A428 Black Cat to Caxton Gibbet improvements

9.40 Joint Position Statement with the Executors of N A Alington in
connection with The Little Barford Estate

**9.40 Joint Position Statement with the Executors of N A Alington in
connection with The Little Barford Estate**

Version	Date	Status of Version
Rev 1	5 October 2021	Deadline 3

APPENDIX 6 EXECUTOR'S PROPOSAL

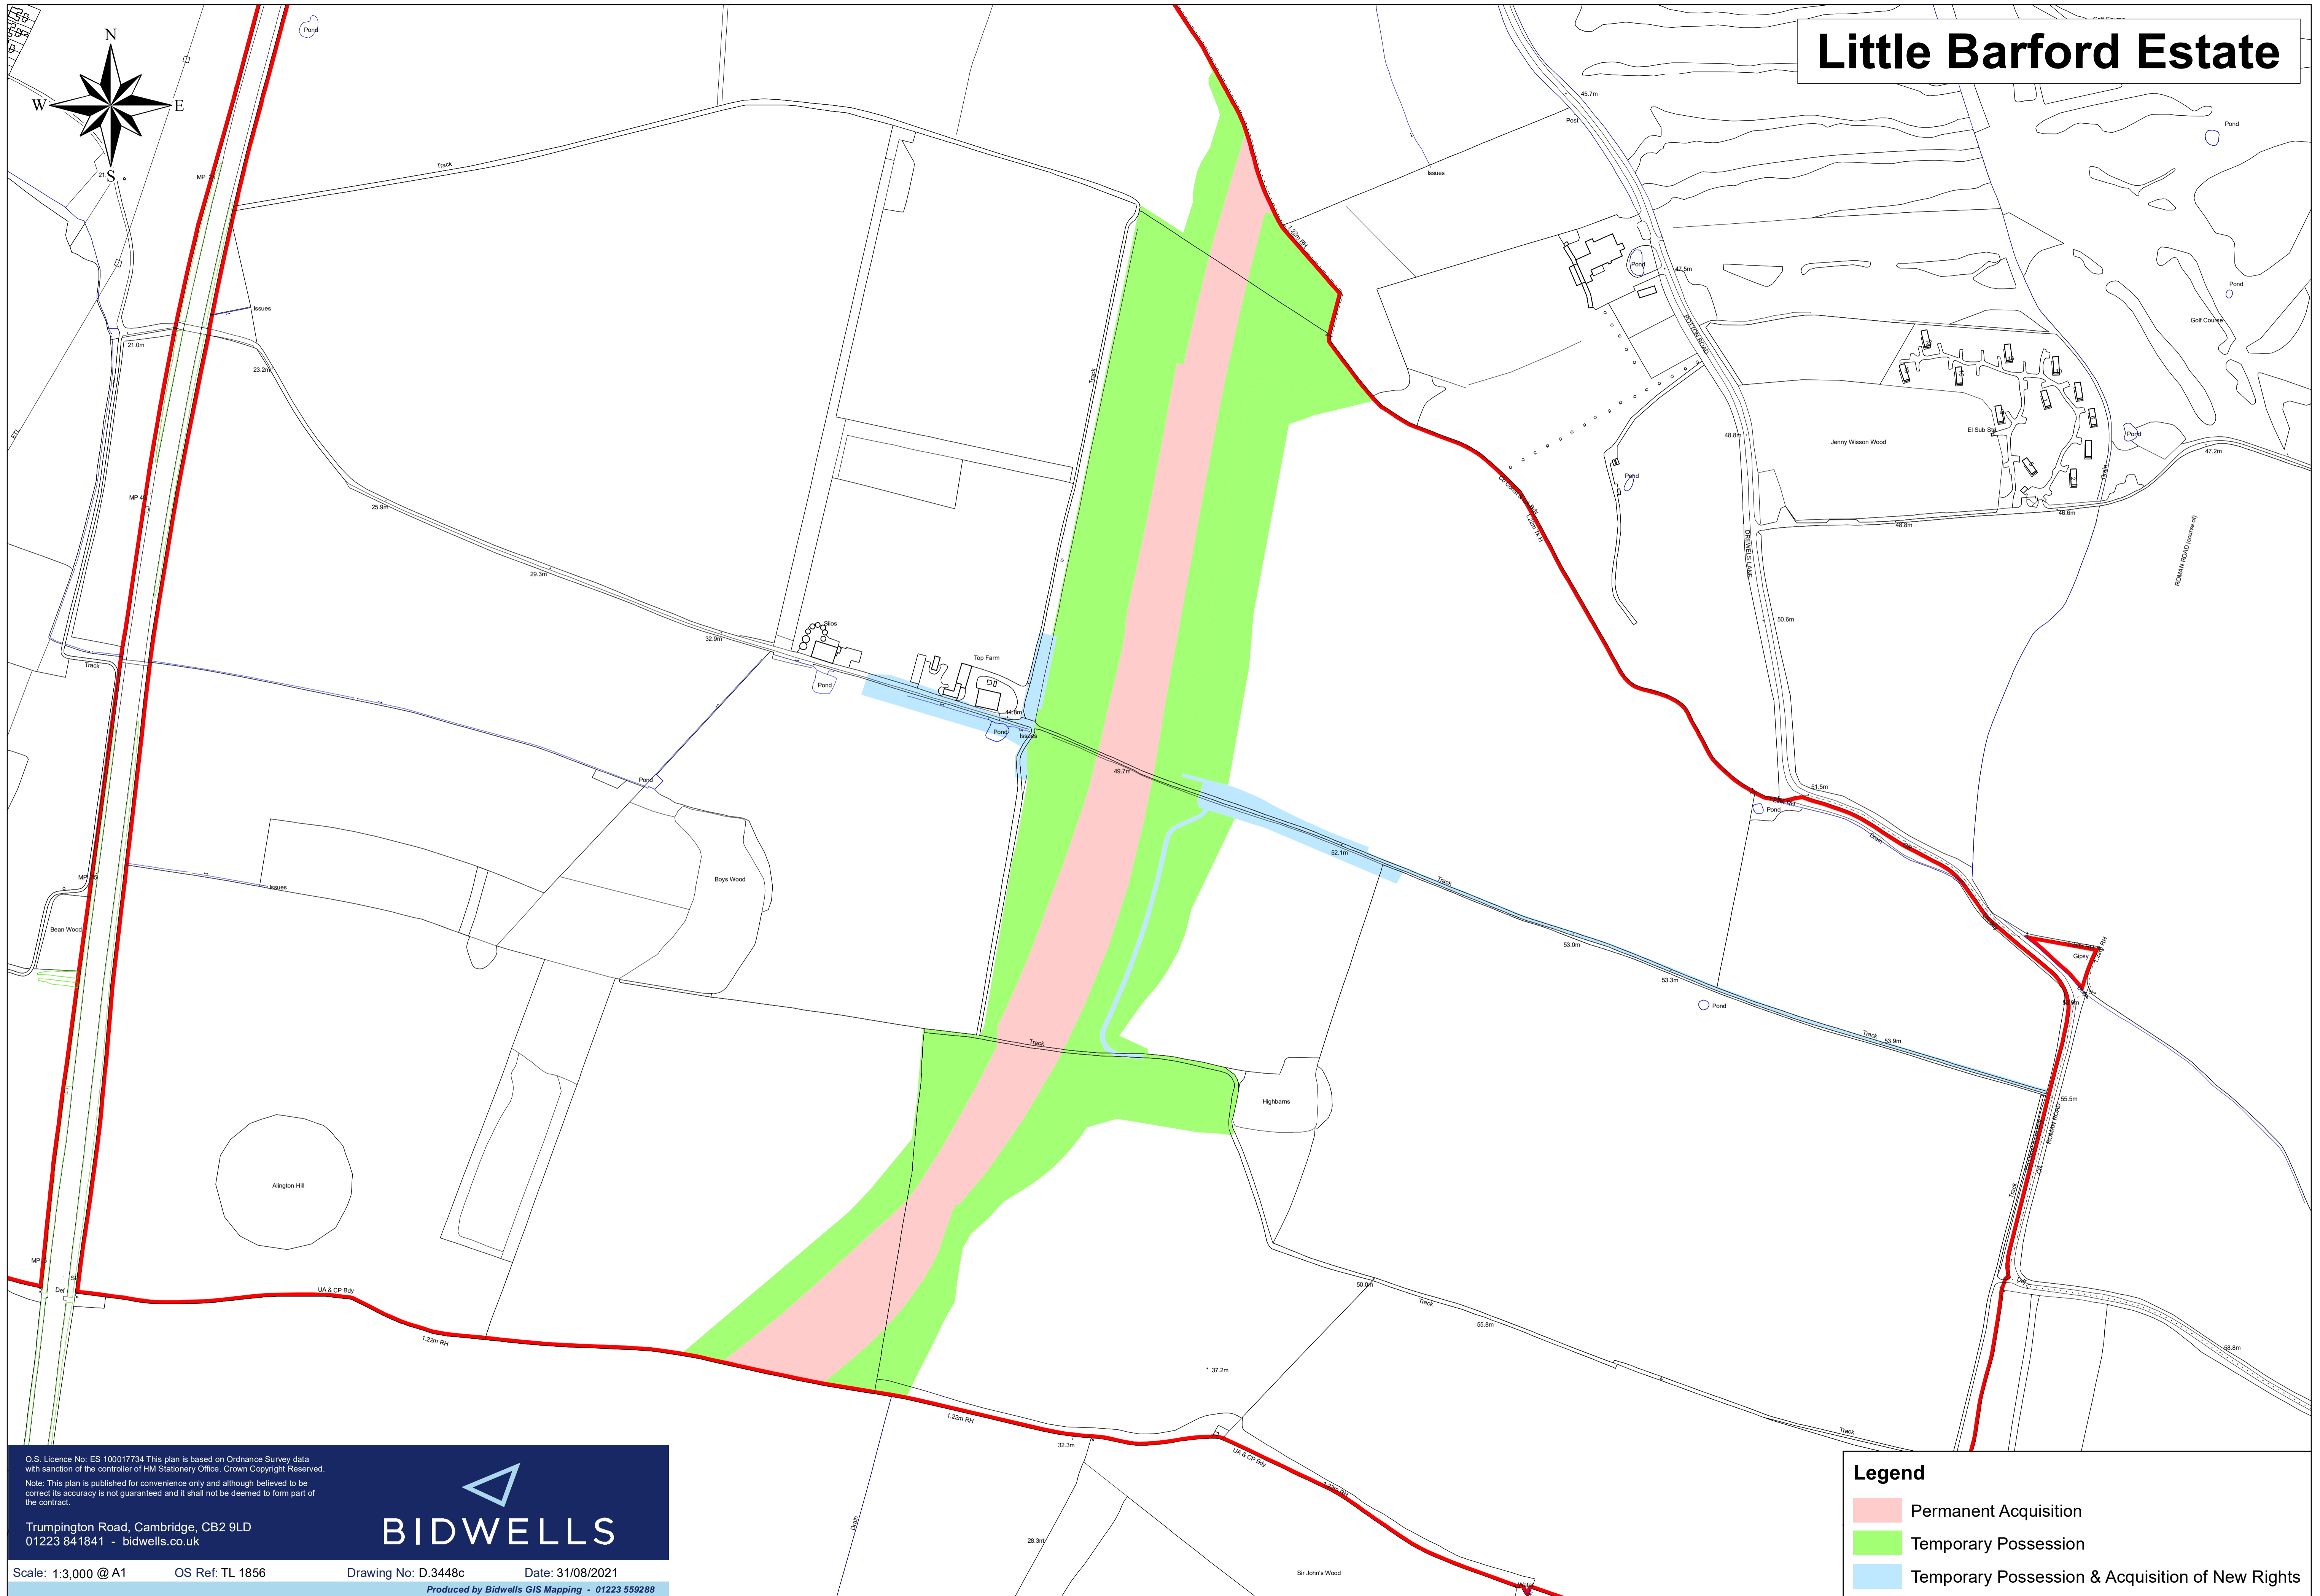
The Executors of N A Alington	The Applicant	Current Position
<p>Severance of the Farm and Proposed Overbridge Specification</p> <p>The proposed overbridge is of insufficient capacity to allow unrestricted use by current farm machinery, impeding the efficiency of the farm.</p> <p>The principle of providing no more than equivalent capacity does not allow for the changes in farming practices, which historically have led to larger farming units operating larger farm machinery. It has no regard to possibly alternative or additional uses.</p> <p>Failure to do this would leave the Executors in a worse position than currently, in a manner that cannot readily be dealt with by financial compensation. A wider capacity bridge is required.</p> <p>The Executors are seeking a much wider bridge, with a width sufficient for current and future farm equipment without the need for demounting or disassembly. This would allow uninterrupted access for working farm equipment.</p>	<p>Review of the available topographical survey shows that the width of the existing stone track running from Potton Road through to the farm buildings is generally 3.2m wide. An existing hedge runs along the southern side of the track and set-back from the edge of the track by approximately 1.0m.</p> <p>The details provided by Executors to N A Alington of the agricultural machinery used on the farm confirms that the maximum width of the equipment is 12.0m, therefore, it is currently not possible for this equipment to transit along the existing access track without being folded up or the header removed.</p> <p>In view of the above (i.e. equipment needs to be folded up or the header removed) the maximum width of vehicle that needs to be accommodated across the structure is 4.3m wide.</p> <p>The Applicant does not understand that the identified equipment is permanently stored on the farm as the Executors have confirmed that they contract works to Davison & Co. The equipment is therefore transported or driven to the farm via the local road network and in particular via</p>	<p>The Applicant is unable to agree to the request put forward by the Executors of N A Alington to increase the carriageway width across the accommodation access bridge at Alington Top Farm.</p> <p>The Applicant is committed to continuing engagement with the Executors of N A Alington on this matter.</p> <p>The Applicant has received a letter from the Developers representing the Estate and wishes to discuss with the Executors their proposal.</p>

The Executors of N A Alington	The Applicant	Current Position
<p>The bridge requested is of similar design to that provided in the Design Manual for Roads and Bridges, see CD127 fig. 2.1.1N1e with a 7.3m running surface. This is also reasonable future proofing.</p> <p>Although there are no current public rights of way over the track it is noted that the land is being acquired with third party rights to be granted. This raises the prospect of shared use of the bridge and access track. The Executors are also mindful of the proposed rail and road infrastructure and development pressure and a bridge of limited width does not take account of the need for shared access or alternative or sustainable transport options in the future. The provision of a bridge of sufficient width to accommodate shared use would be a prudent investment.</p>	<p>Potton Road. The existing width of Potton Road is currently less than 6.0m (both lanes)</p> <p>Based on the above the Applicant does not consider that the provision of a 7.3m wide carriageway width across the proposed accommodation access bridge is justified and therefore cannot agree to the proposal put forward by the Executors of N. A Alington.</p>

- a. The Executors of N A Alington are seeking a much wider accommodation access bridge at Alington Top Farm with a width sufficient for current and future farm equipment without the need for demounting or disassembly. They have requested that the carriageway width across the proposed structure is increased from 3.5m to 7.3m in line with the requirements of the Design Manual for Roads (DMRB) and Bridges, CD127 fig. 2.1.1N1e.

- b. The Applicant notes that the design standard that the Executors of N A Alington refer to (i.e. DMRB CD127) provides requirements for the highway cross-sections and headroom at structures for motorway and all-purpose trunk roads and is not considered appropriate for use in the design of the accommodation access track under consideration.

- c. Based on the evidence that has been provided the Applicant considers that the requested increase in width of carriageway is not justified and it is unable to agree to the request put forward by the Executors of N A Alington to increase the carriageway width to 7.3m.
